Viking CCS Pipeline

**Environmental
Statement Volume IV –
Appendix 5-3:
Response to Scoping
Opinion**

Document Reference: EN070008/APP/6.4.5.3

Applicant: Chrysaor Production (U.K.) Limited,
a Harbour Energy Company
PINS Reference: EN070008
Planning Act 2008 (as amended)
The Infrastructure Planning (Applications: Prescribed Forms
and Procedure) Regulations 2009 - Regulation 5(2)(a)
Date: October 2023

3.7.19 **Figure 3-9** identifies the key crossings along the DCO Site Boundary. A higher resolution version of the same Figure is provided in *ES Volume III: Figures (Application Document 6.3)*.

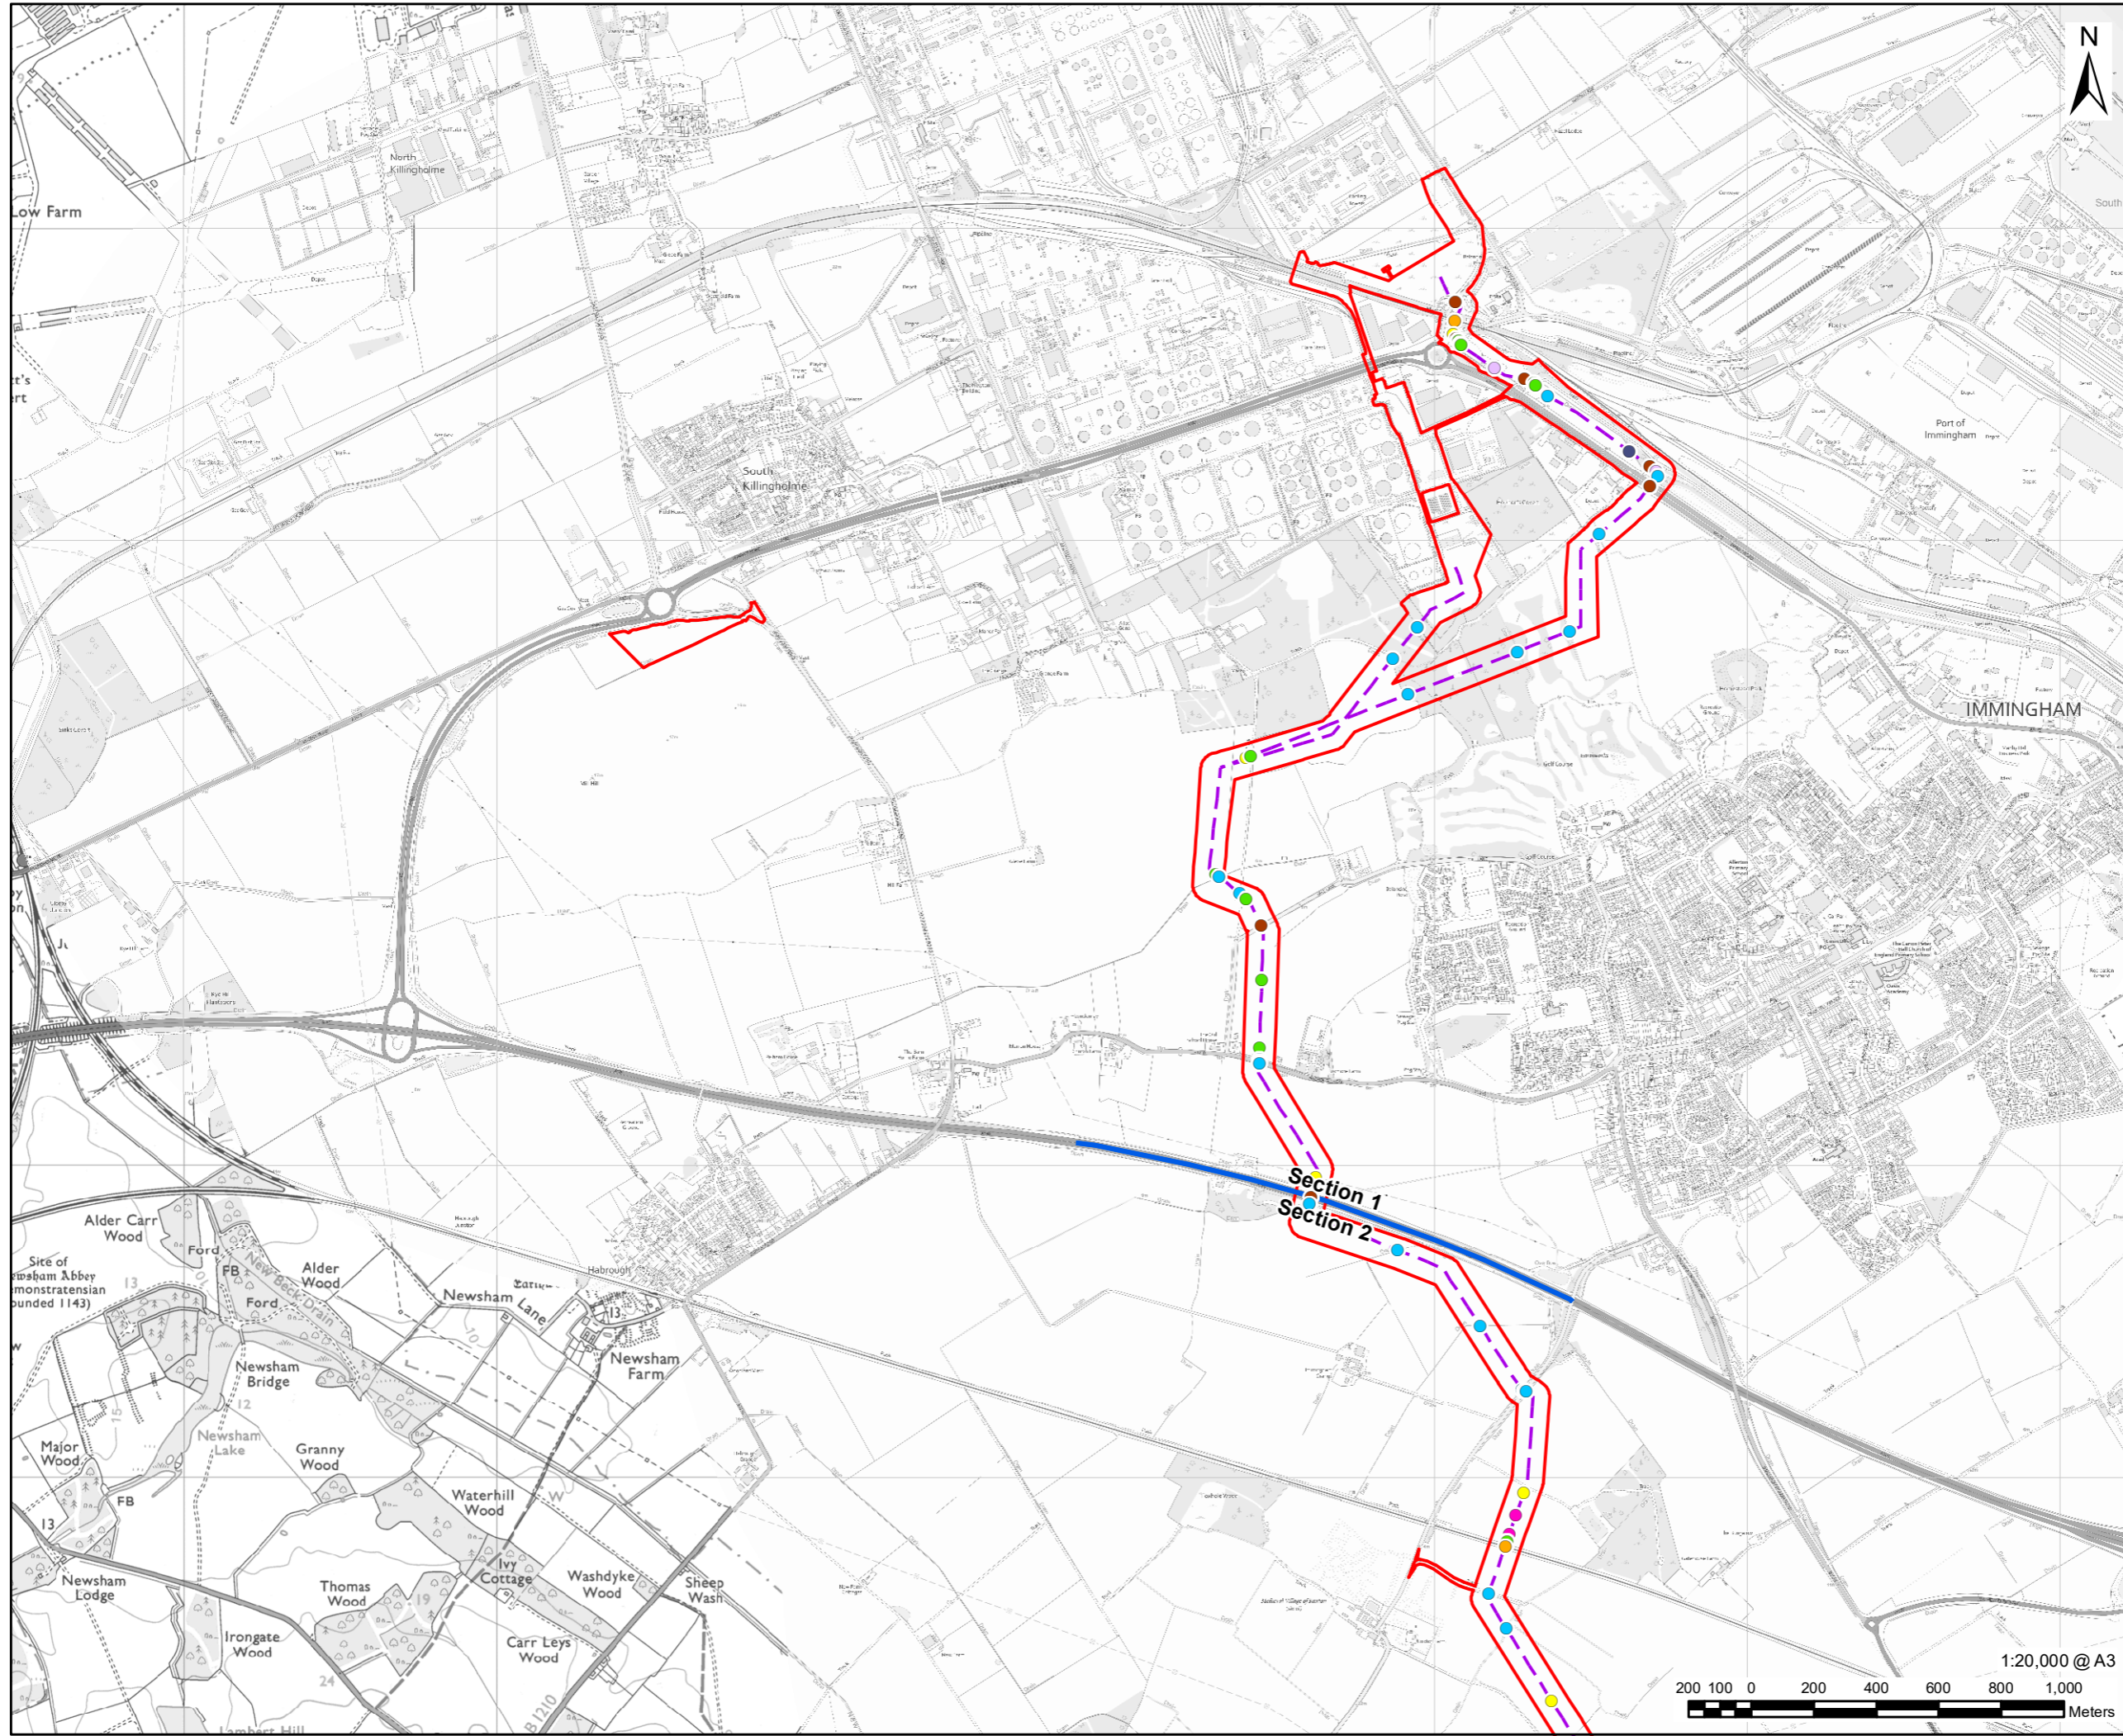
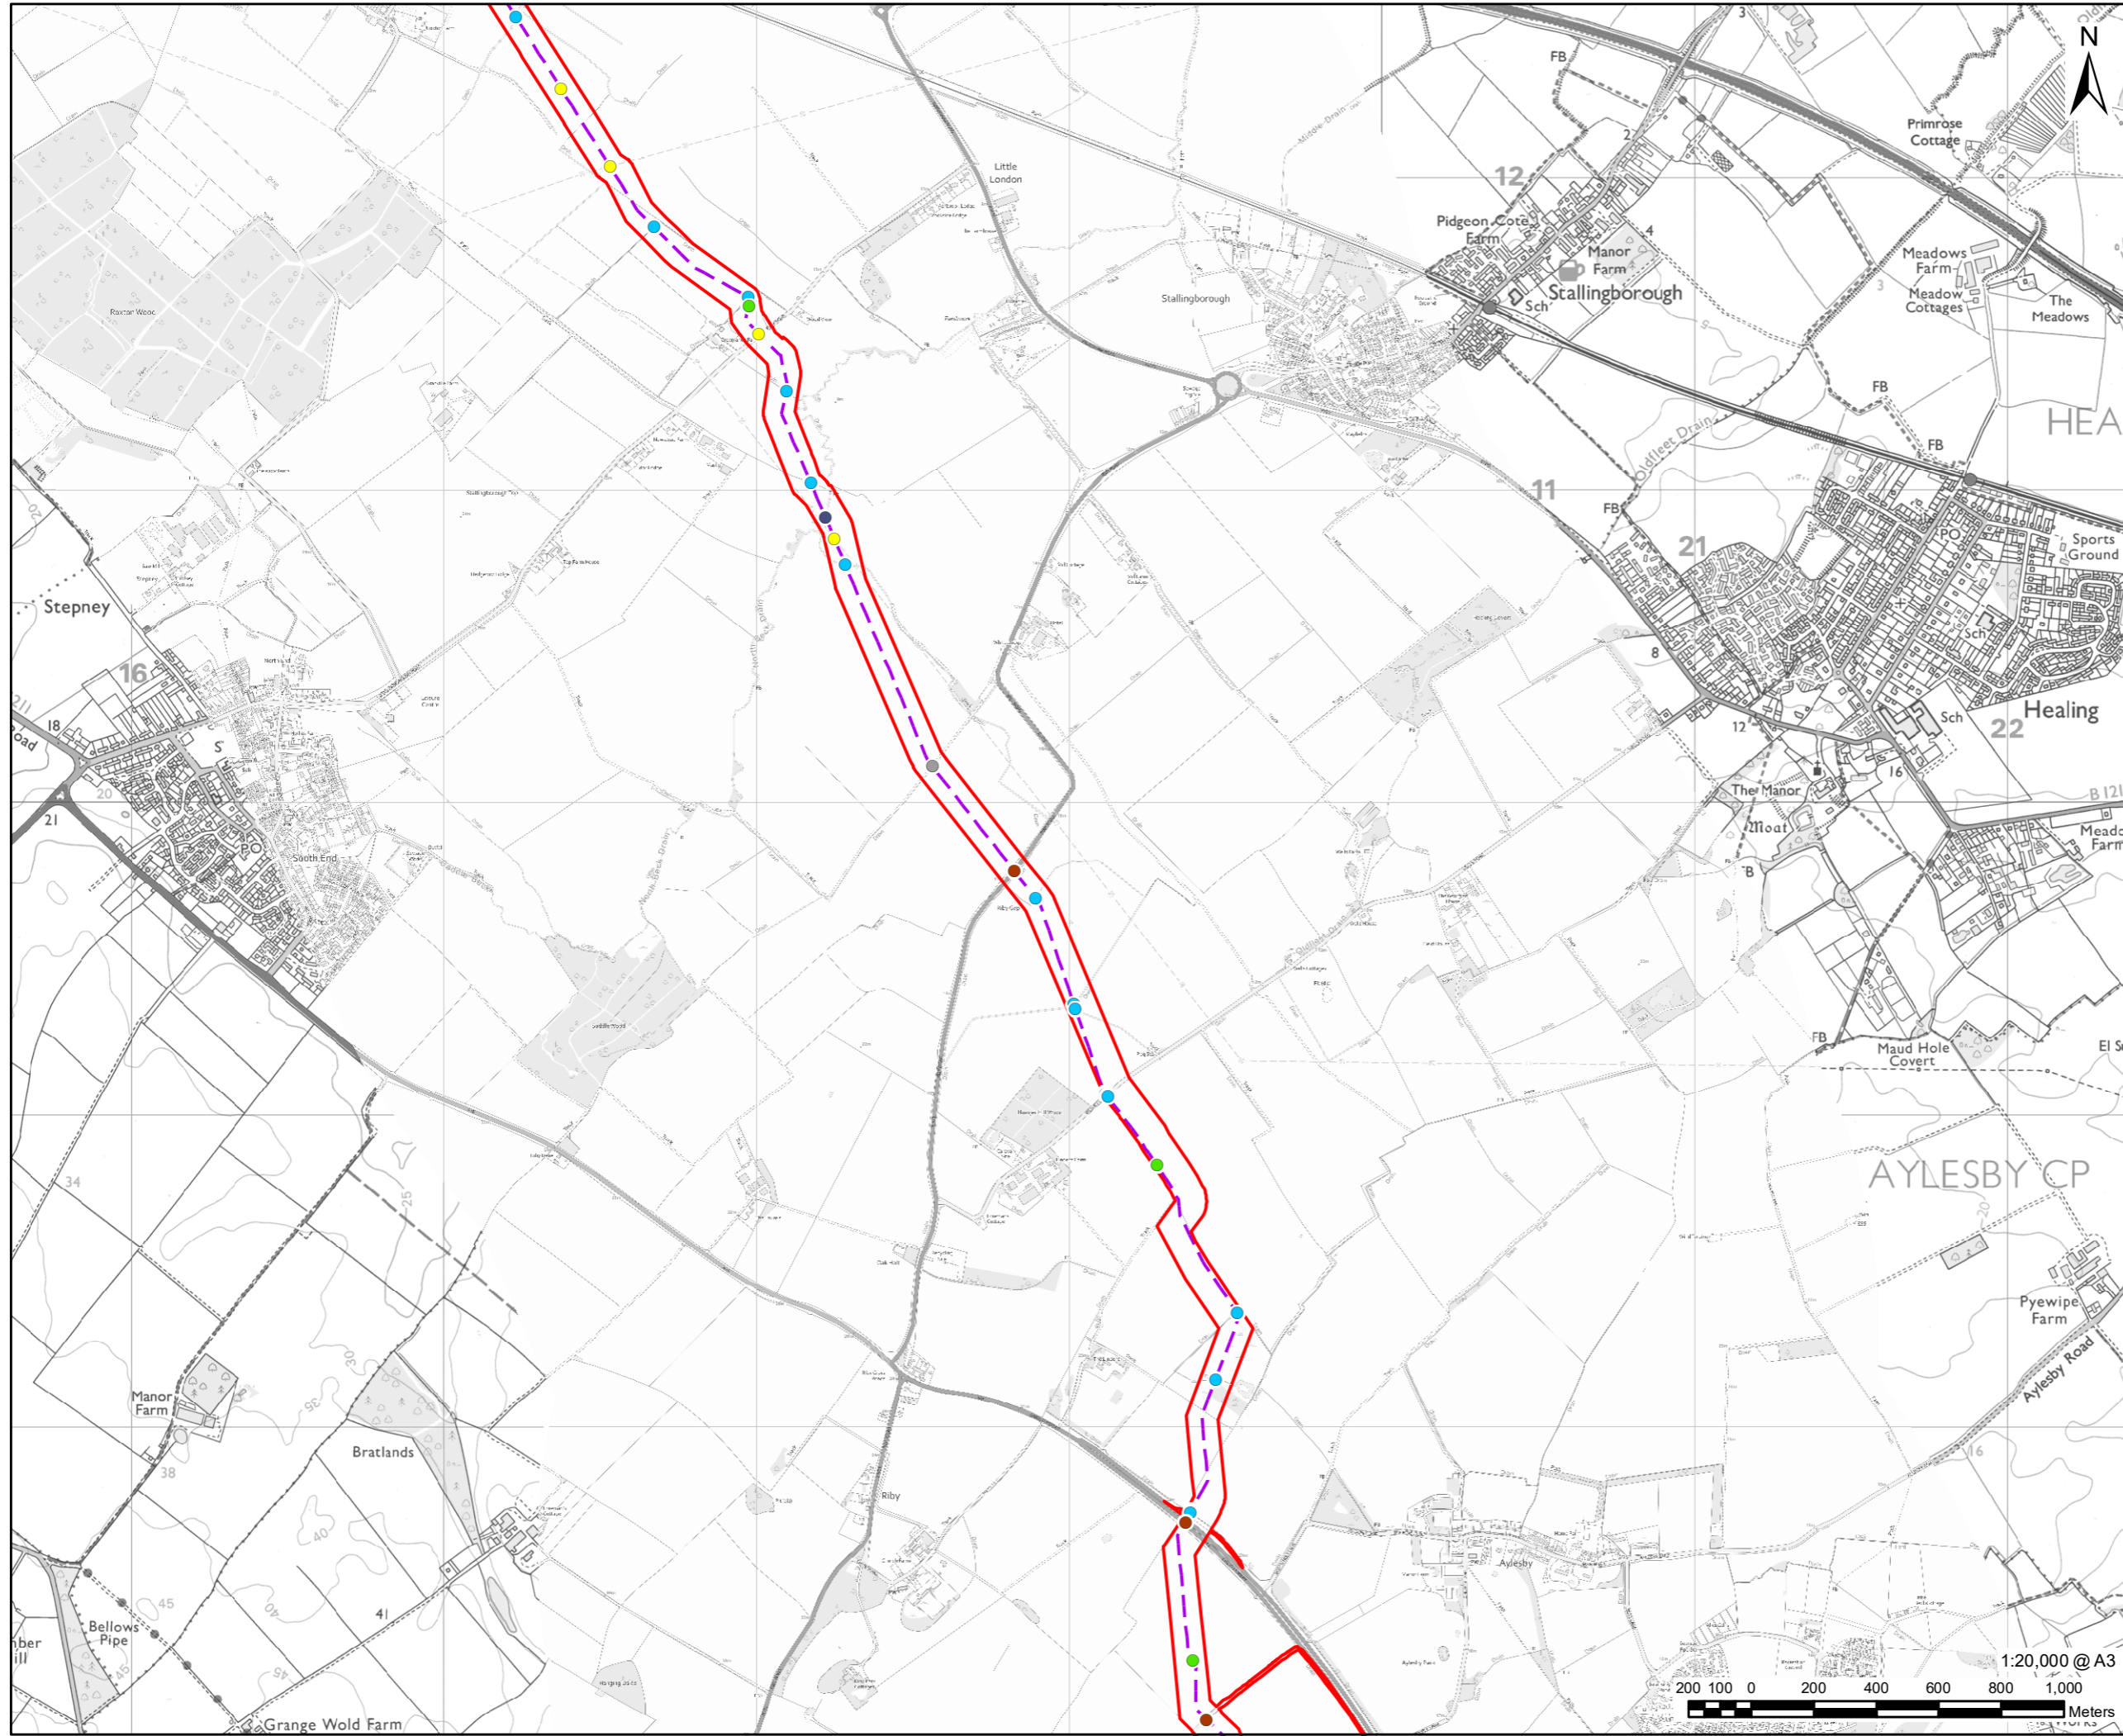
2.1.3	Section 2.5, 2.15	Pipeline crossing methodology	Paragraph 2.5.20 explains that open cut trench installation is the likely crossing method to be adopted, with consideration given to trenchless techniques in particular locations. The further information in Table 2-4 and Section 2.15 is noted. Where a particular installation method at a particular location is committed to or assumed for the purposes of	<i>ES Volume IV Appendix 3.2 Crossing Schedule (Application Document 6.4.3.2)</i> details each crossing required for the Proposed Development as well as the method in which it will be crossed, whether open cut or trenchless. These are displayed

ID	Ref	Description	The Inspectorate's Comments	Applicant's Response
			assessment, this must be clearly explained in the ES and secured in the dDCO.	in <i>ES Volume III Figure 3.9 (Application Document 6.3.3.9)</i> .
